STEPHEN STREET ELEVATION

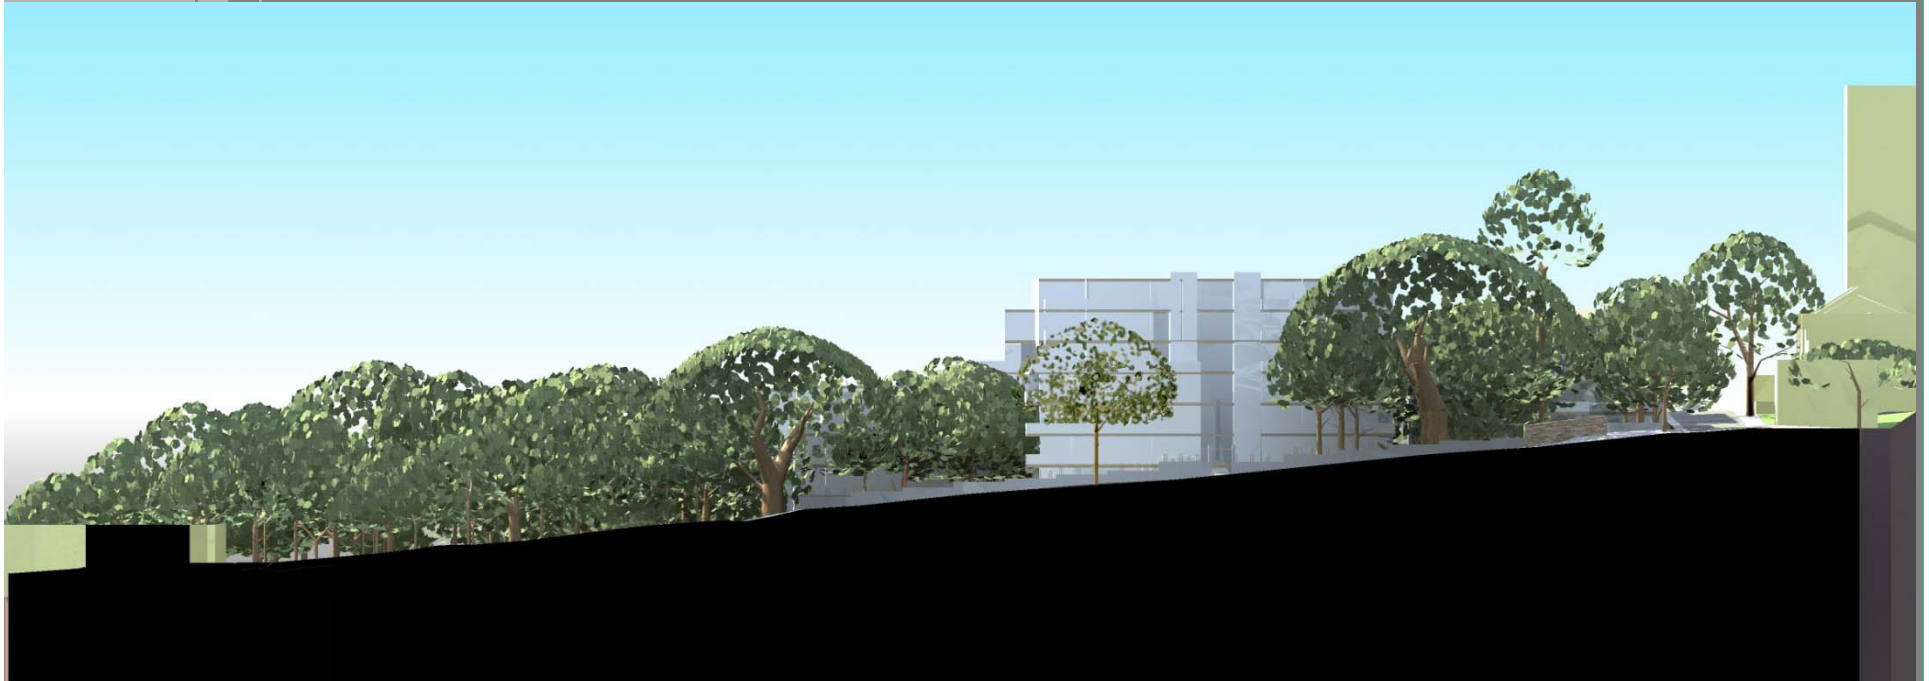
Some of the buildings on Stephen Street have zero setback while the setback of the RACF building is as little as 3.25 meters. The RACF building is to be situated directly across the street from 40 Stephen Street with only 16 meters between our living room windows and the proposed structure. This negatively affects our privacy and our views. This lack of setback, mirrored underground in the development's car parks and basements precludes the retention or growing of significant sized trees along Stephen Street.

The proposed service entry on Stephen Street is problematic on a number of levels. Stephen Street is a narrow cul-de-sac and is unsuitable for such purposes, particularly when the RACF building could readily be serviced from the main Brown Street entrance. To locate the entrance directly opposite the entrance to 40 Stephen Street seems unthoughtful at best when you consider the noise of trucks and vans arriving, turning, reversing and leaving our street. The cliffs and building in the area at present create a funnel affect which magnifies the noise at street level and passes it up to the upper floors of 40 Stephen Street. How much worse would this echoed noise be if the proposed development were allowed to go ahead, given the height and lack of setback of the proposed buildings on Stephen Street and the removal of all trees.

BROWN STREET ELEVATION

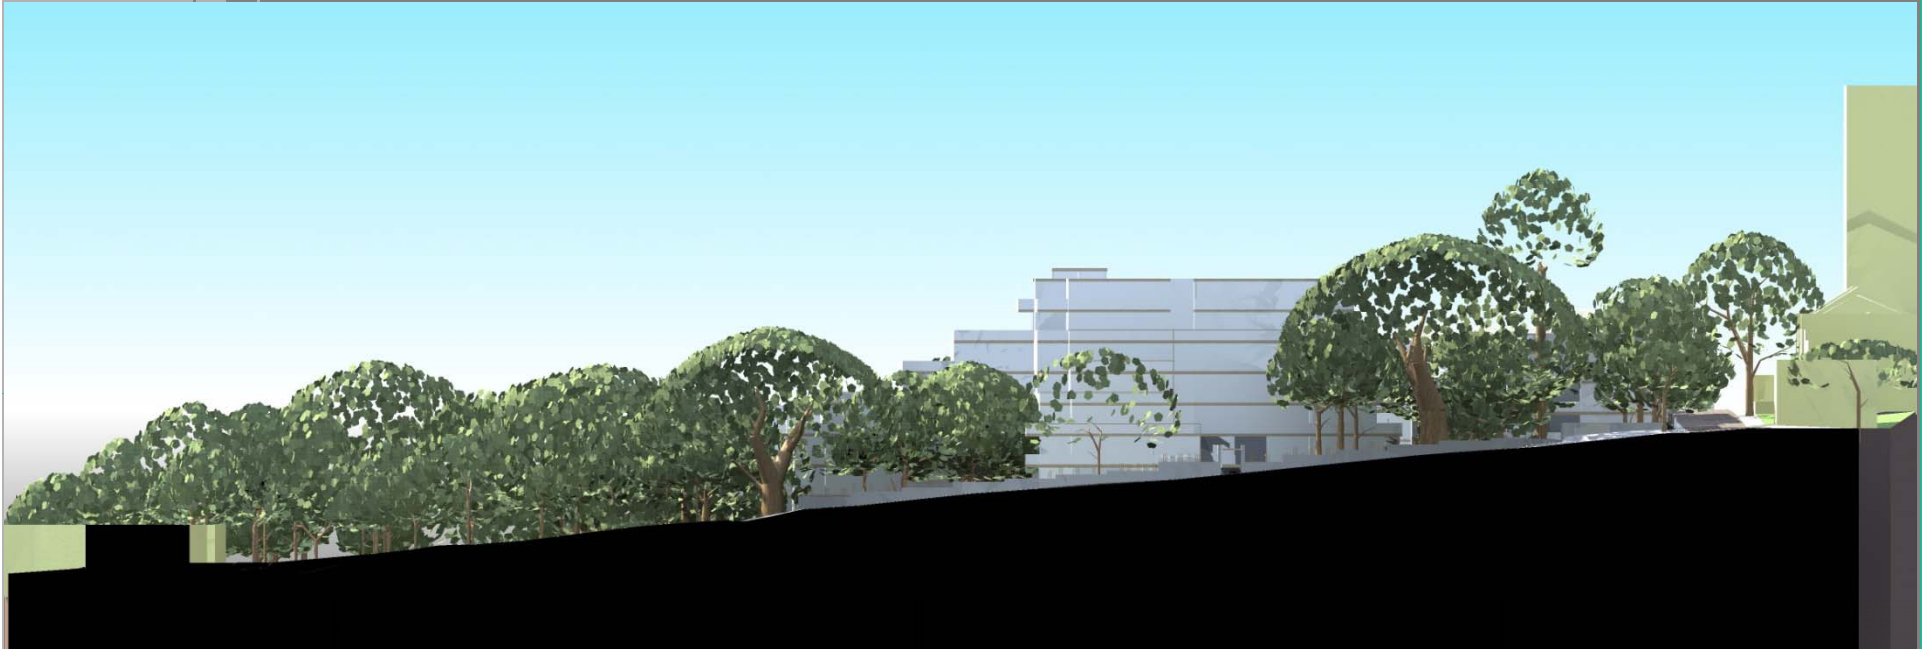
From the view analysis provided by the developers for our apartment the tall building on Brown Street is not situated below the tree canopy as promised. It sits at least 2 stories above the vast majority of the trees and as such should be reduced by 2 floors.
